CITY OF PORTLAND

Permit Number: 050957

has permission to Build a 26' x 30' Detached "back house"

AT 47 SUNSET AVE

1ST FLOOR + FOUNDATION LAYOUT

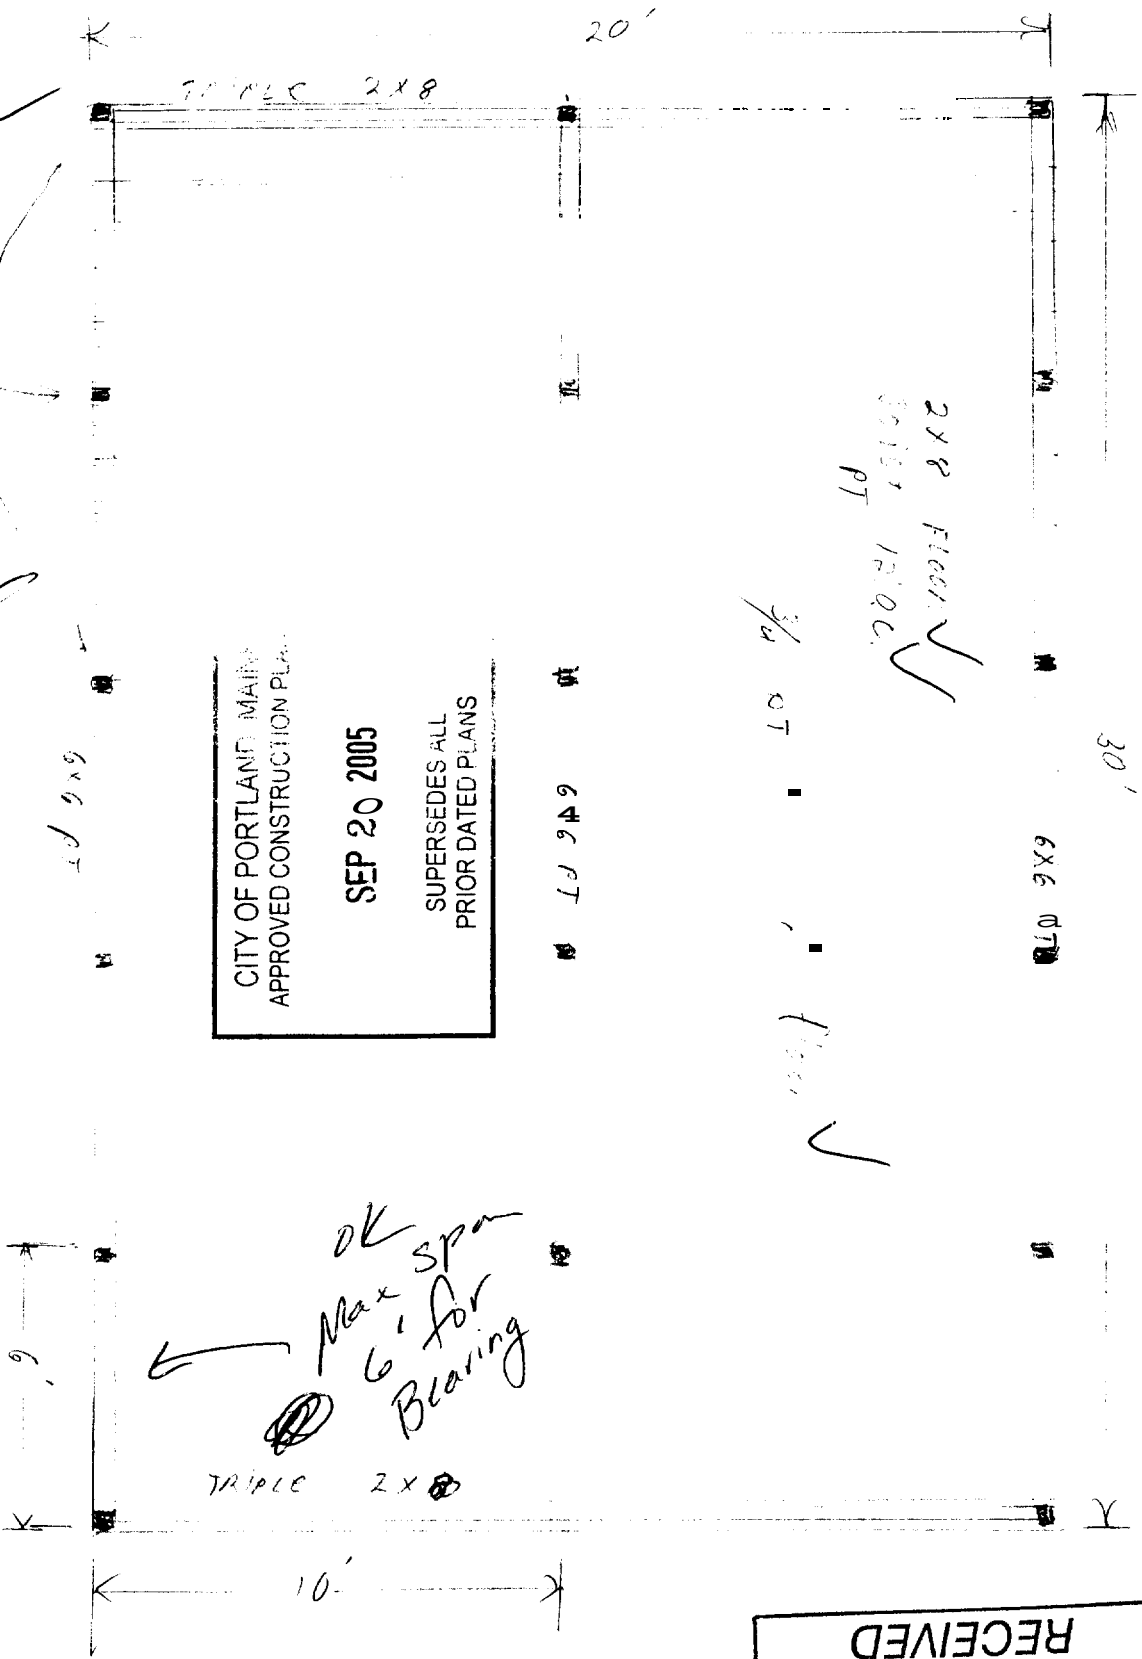
Dept: Zoning	Status: Approved	Reviewer: Tammy Munson	Approval Date: 09/20/2005
Note:			Ok to Issue: <input checked="" type="checkbox"/>
Dept: Building	Status: Approved with Conditions	Reviewer: Tammy Munson	Approval Date: 09/20/2005
Note:			Ok to Issue: <input checked="" type="checkbox"/>
1) An attic access measuring a minimum of 22" x 30" must be installed.
